Application for a non-material amendment following a grant of planning permission.

Development of new cover at ground level to existing internal courtyard with flat roof and rooflight & new two storey building to north east corner of property to provide a stretcher lift, storage on ground floor and first floor office

Reference number:	R/117/19/PL
Date of decision	12/08/2019

Internal alterations to the two storey lift, store and office building to the north east corner of the property requiring changes to doorway and fenestration affecting the ground floor as follows:
Door removed from east elevation. Window removed from north elevation. New door on north elevation to provide fire escape.

PROPOSED ELEVATIONS 1:100

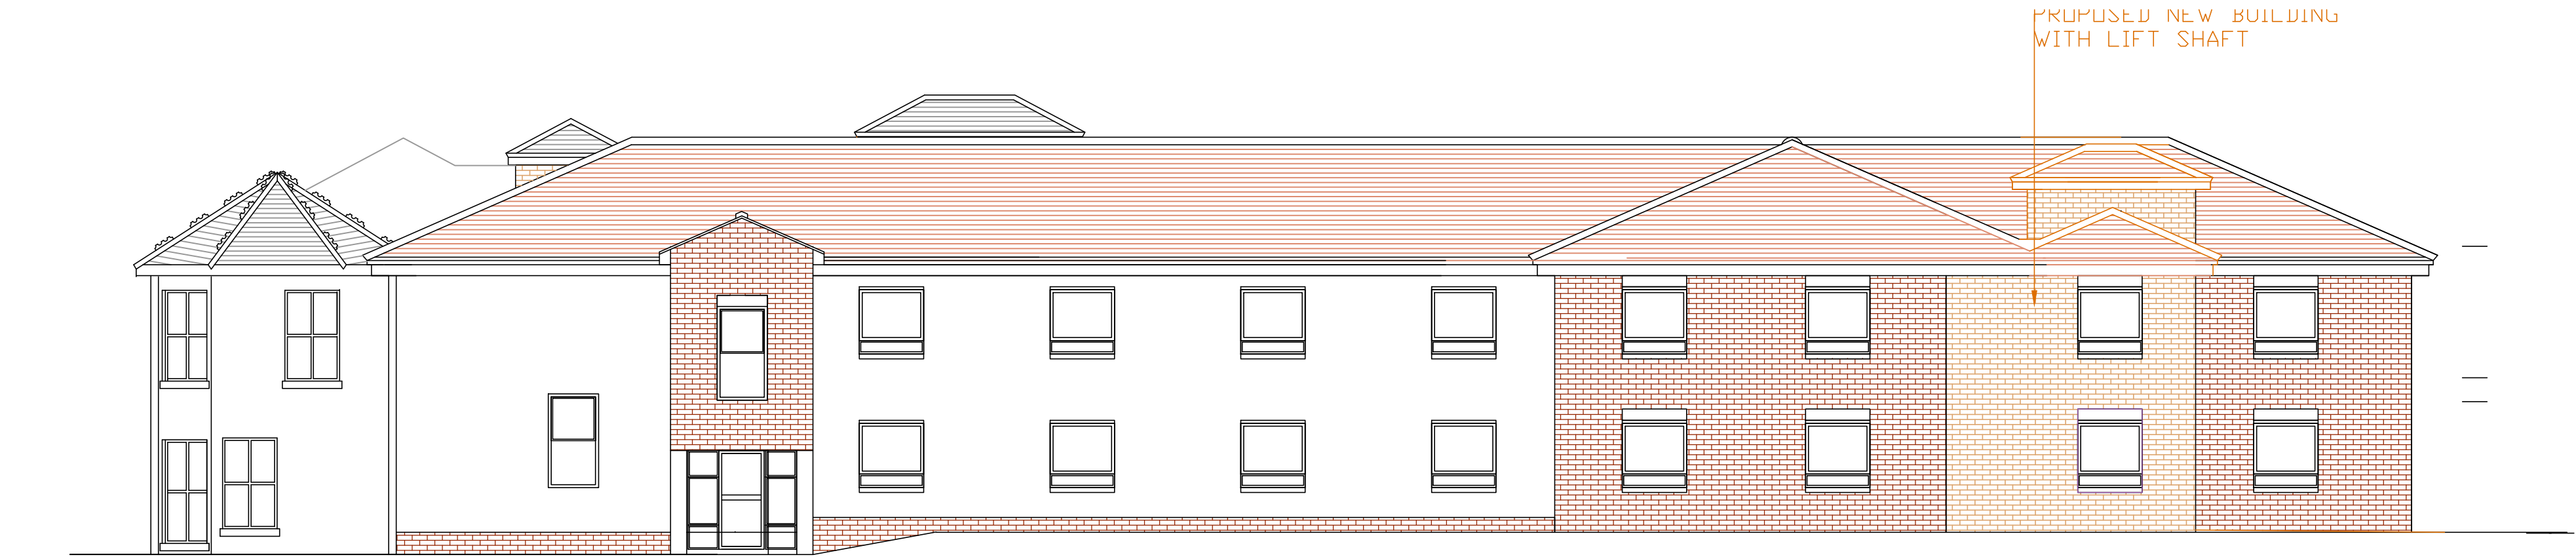
Building Control required internal alterations to the plans for Fire Escape and Lobbies. This, in turn, required changes to the external doors and fenestration as described and as shown in the submitted plans.
